Q52 In anticipation of the question Q26 not being answered again, in HE responses to previous submissions, we ask again, is HE attempting to place 15000 speeded up vehicles onto the A38 Kingsway Island hospital site, (Oral hearings tape 18th February) the most polluted site in the East Midlands? (FOE Enc 1)

National Friends of the Earth have sent their submissions, below, regarding HE responses to their evidence

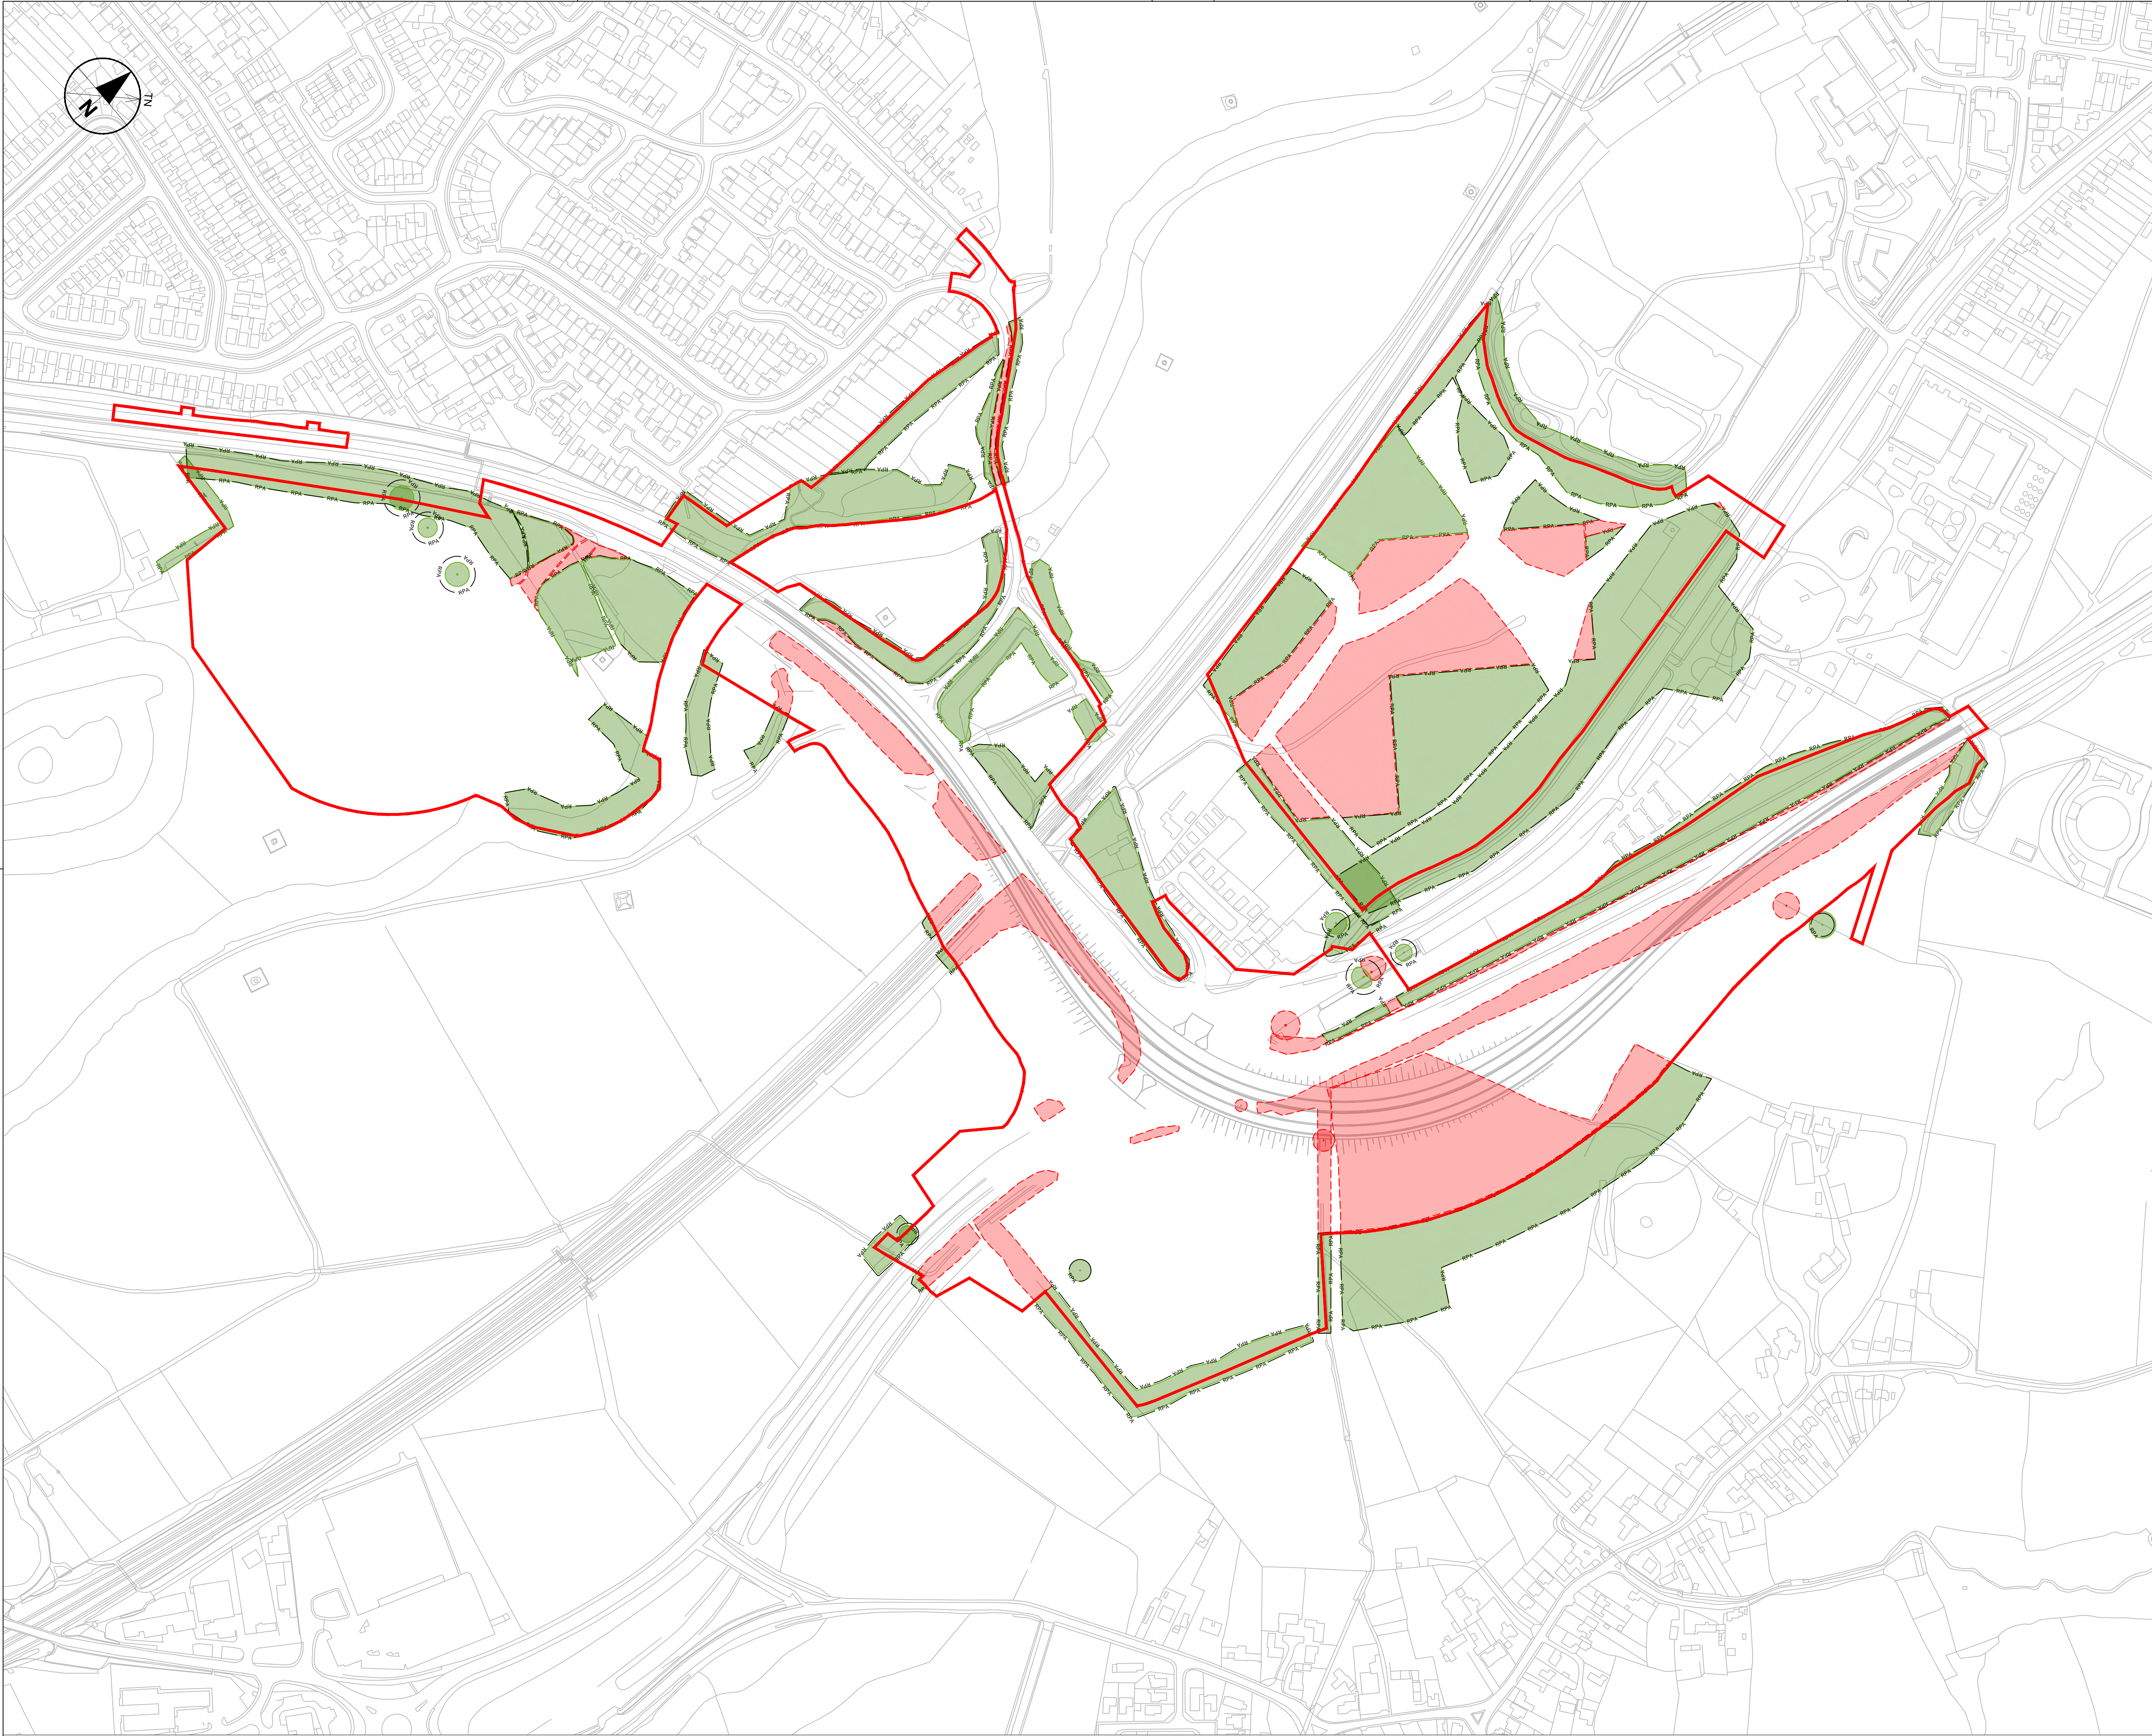
Q55 HE response regarding air quality in the park being maintained once the trees are gone, is illogical, as the trees/scrub/hedges form a barrier to the current pollution, which, when destroyed, will mean that air quality in the park will be worsened. Does HE agree that the current tree cover/hedgerows/copses forms an air cleaning function, for vehicular air pollution?

Drawing Title
**FIGURE 10.1
KINGSWAY JUNCTION
GEOLOGY & SOILS STUDY AREA &
FEATURES**

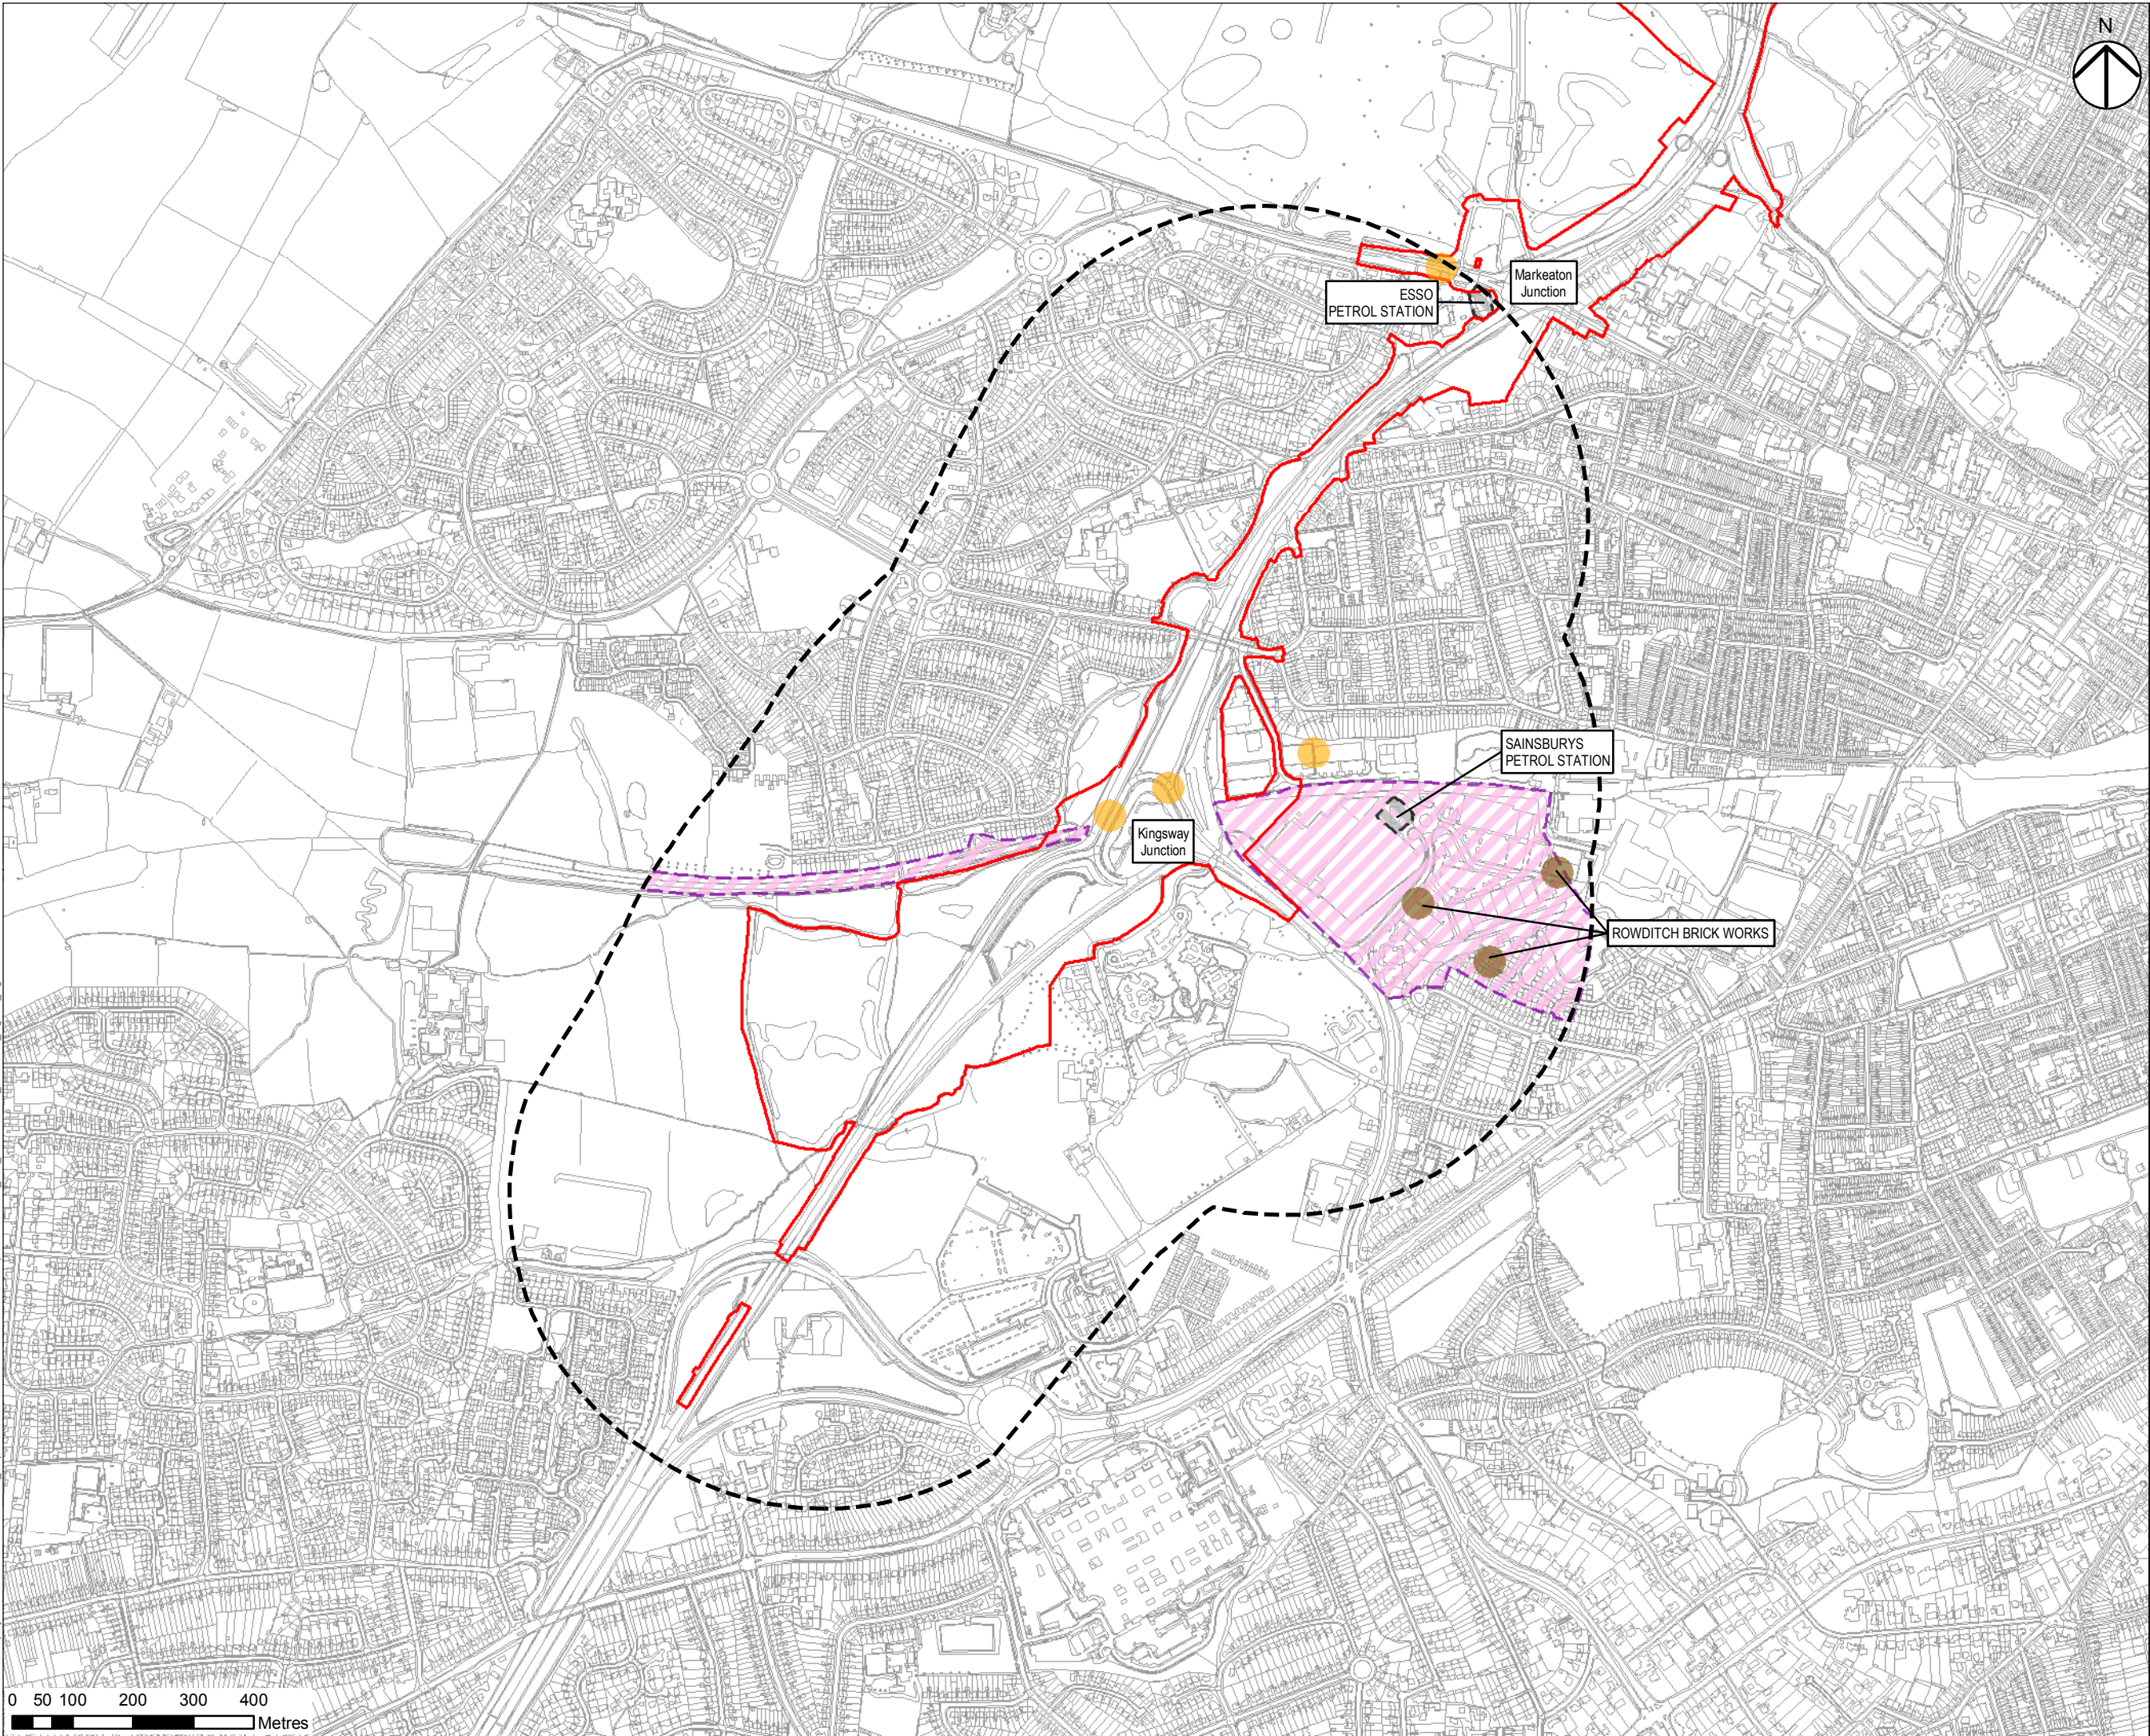
Q56 Re HE response to Q30, Q32 -HE states that, regarding landfill emissions at Kingsway "It is not considered that any additional CO2 emissions will arise as a result of the scheme construction works" then admits that **"a further site investigation is being planned"** and that there

'risks to construction workers in confined spaces and/or excavations from at least one ground gas or from oxygen depletion at each of the junctions,' and

"CO2 and other ground gases in this former landfill area need to be taken into account"

It is quite obvious that, until these 'further investigations' can take place, HE cannot make statements regarding CO2 and safety of workers, 'negligible effect' on residents', shoppers, drivers at the junctions. In responses to Q32 the 'negligible risk', then suddenly becomes 'very low' risk, further on in the response, to construction workers, which does nothing to clarify the situation. In view of the extent of the contamination being unknown, why would NHS Kingsway Hospital not be informed, especially as their business is health?

Q57 Why were FOUR of the trial pits at Kingsway halted at 1-2metre depth and why has worker safety not been properly evaluated ie **"scheme effects upon construction workers was scoped out of the impact assessment"** and who advised that worker safety should be 'scoped out', despite **'further investigations'** needing to take place?

Q58 (re HE response to Q33,Q34) Regarding asbestos, HE states that there is a 'negligible risk' to workers and the general public, despite **'further investigations'** being needed. Several trial pits were also halted. Therefore we have no confidence in HE statement that there is 'very low risk' of pollution to controlled waters, as they themselves do not know the extent of the contamination.

Q64 HE response 'runoff will be collected and controlled' As groundwater levels/run-off rise, with increased rainfall, in line with the climate emergency, does HE agree that rising levels of groundwater/run-off will cause contamination from the Kingsway landfill – a site still set to undergo 'further investigations – to be brought to the surface and cause further contamination to controlled waters?
